**From:** Contact Centre (CRM) <contact@ribblevalley.gov.uk>  
**Sent:** 13 February 2025 16:08  
**To:** Planning  
**Subject:** Planning Application Comments - 3/2024/1016 FS-Case-687405641

**Planning Application Reference No.:** 3/2024/1016

**Address of Development:** 1-7 The Picture House, George Street, Whalley, BB7 9TH

STAIR AND BOUNDARY WALL PLAN - 1:50

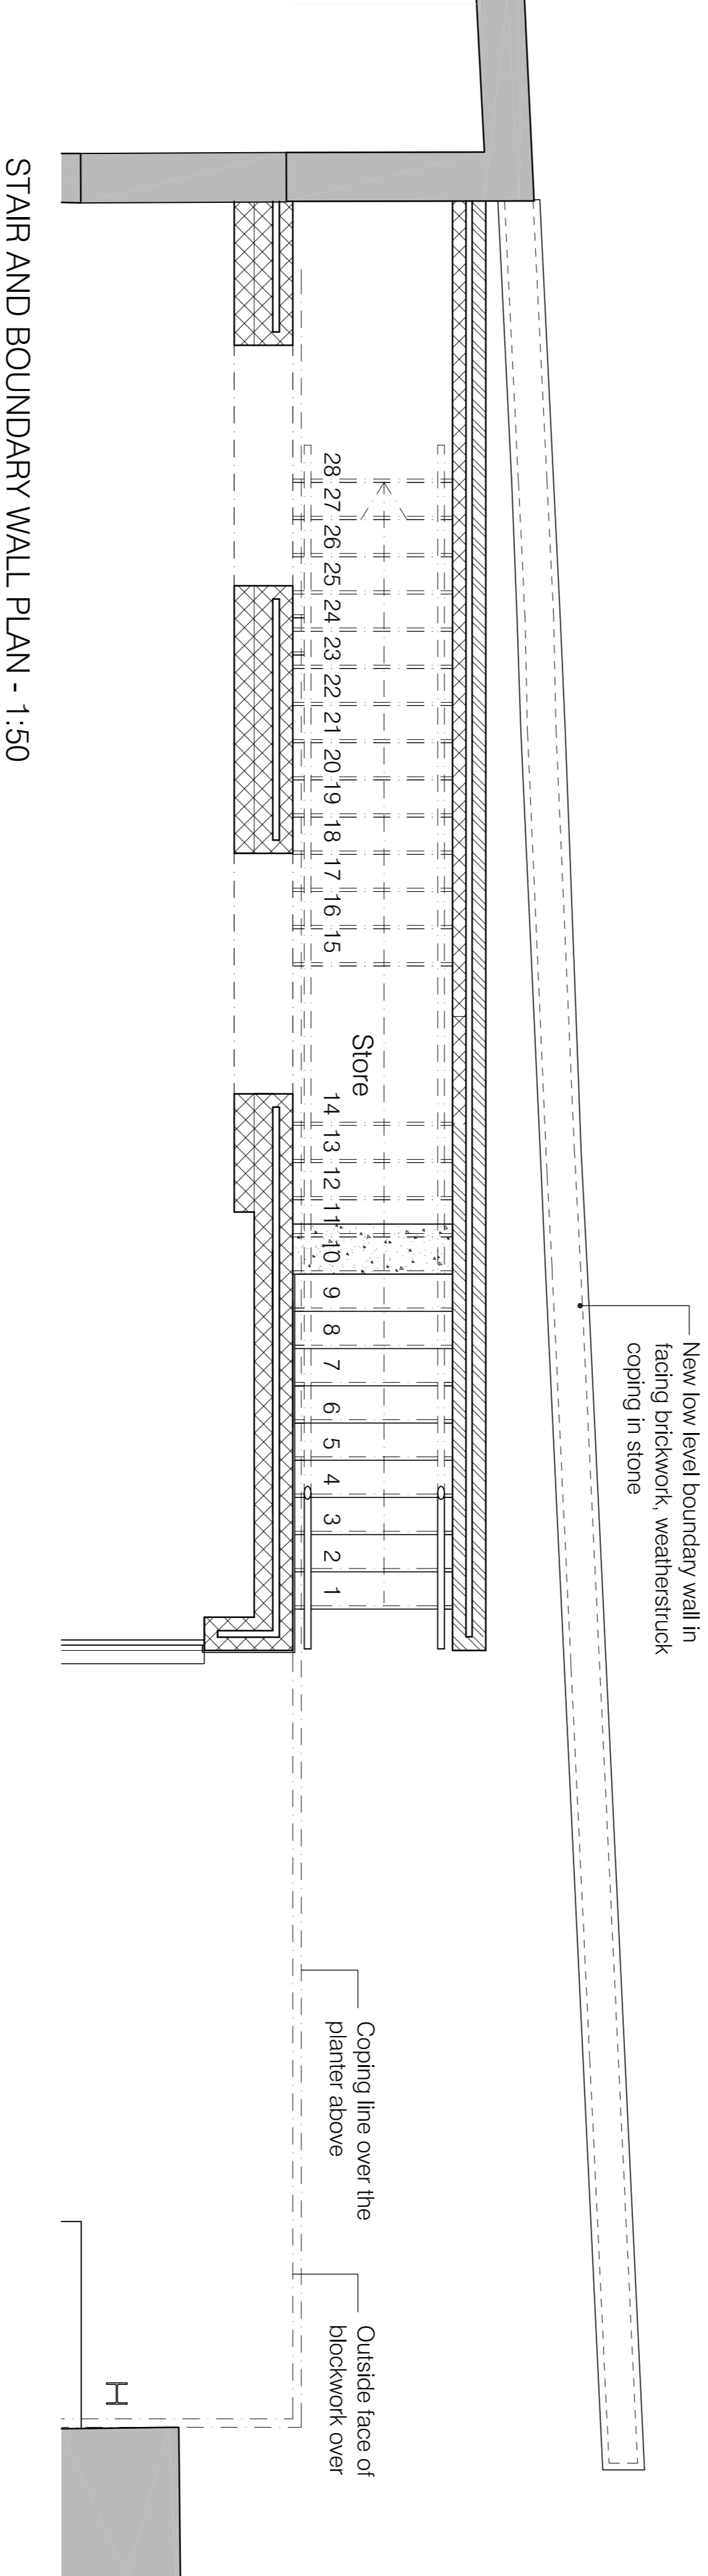
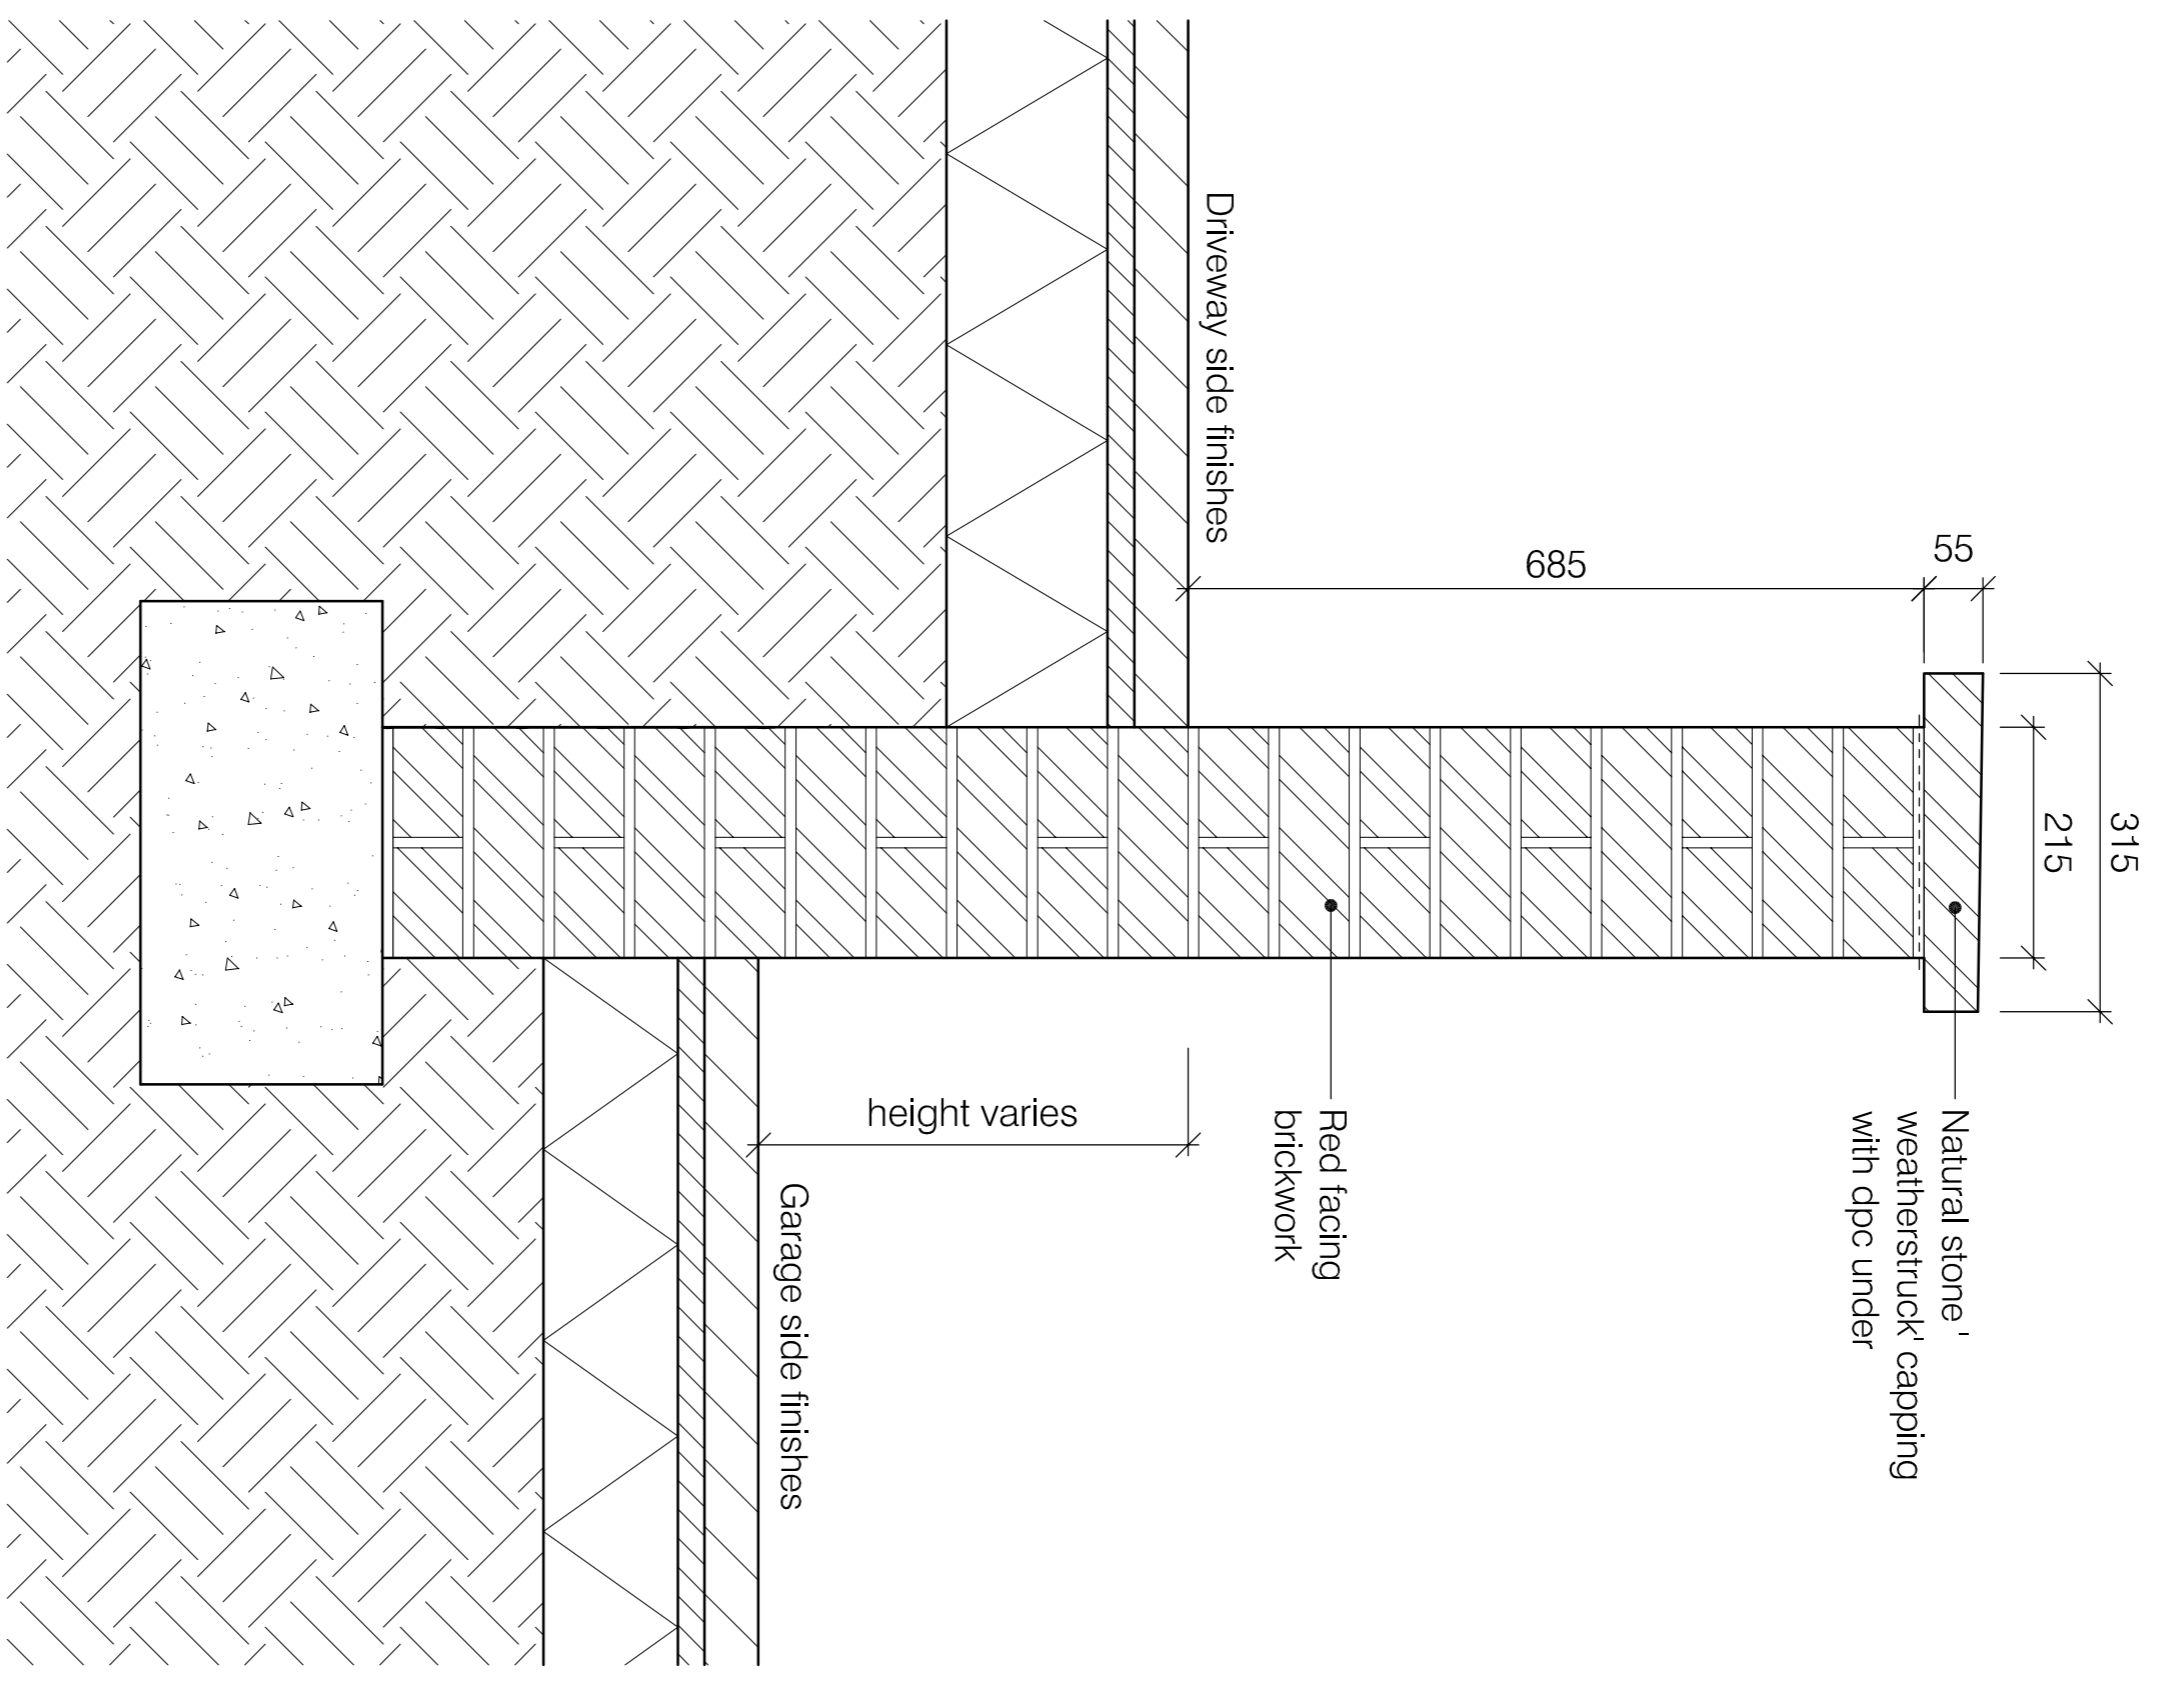
4. The privacy screening to the terrace level has not been installed.
5. The rear boundary wall situation is not as the approved details and the new rendered wall to the stair has an unacceptable bulk and appearance

**DRAWING TITLE**  
 STANDARD WINDOW DETAILS

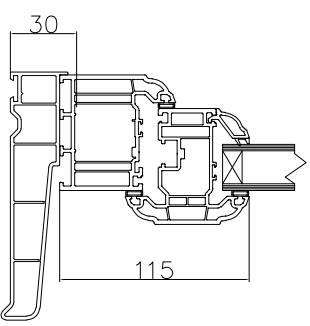
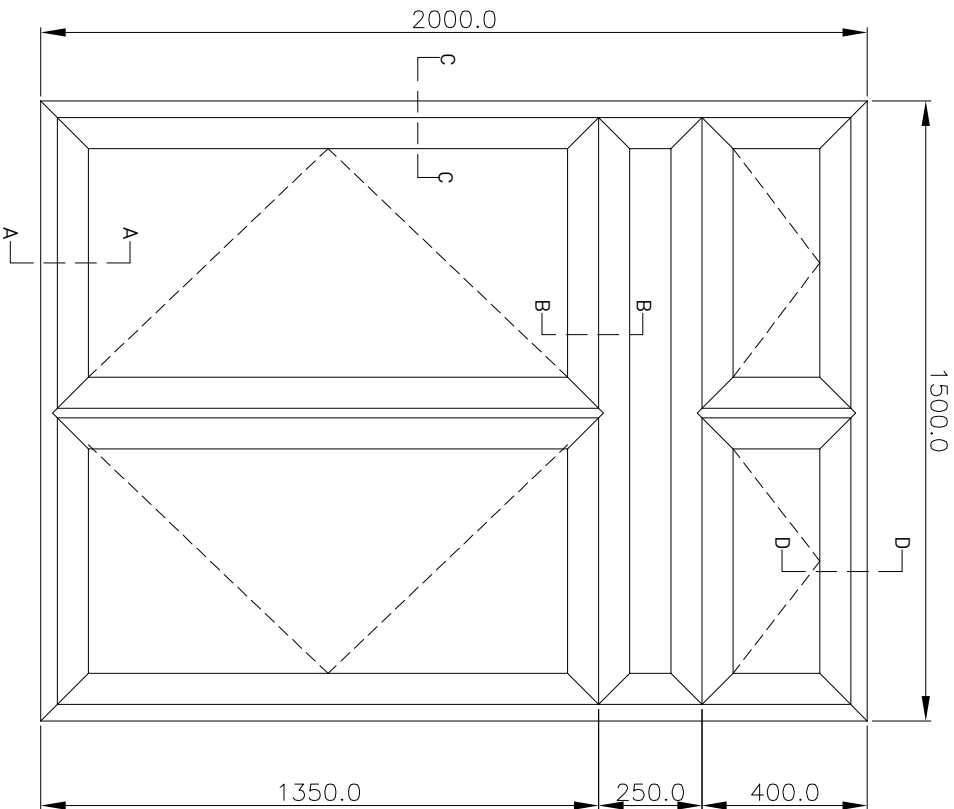
6. The large dormer to the street elevation has been externally finished in aluminium standing seam cladding and not zinc (heritage material)
7. UPVC windows have been installed to the entire development. This (as highlighted by others) remains highly contentious in the conservation area and the authority have already stated that these are unacceptable (app ref 3/2024/0324). The windows are not compatible with the historic character of the area and we reiterate the point that they only serve to undermine the integrity of the original design and the character of the building.  
The applicant's 'study' of the area is a futile attempt to justify the installations. It's apparent that the applicant has failed to listen to the authorities stance on this matter in advance and during the construction work.
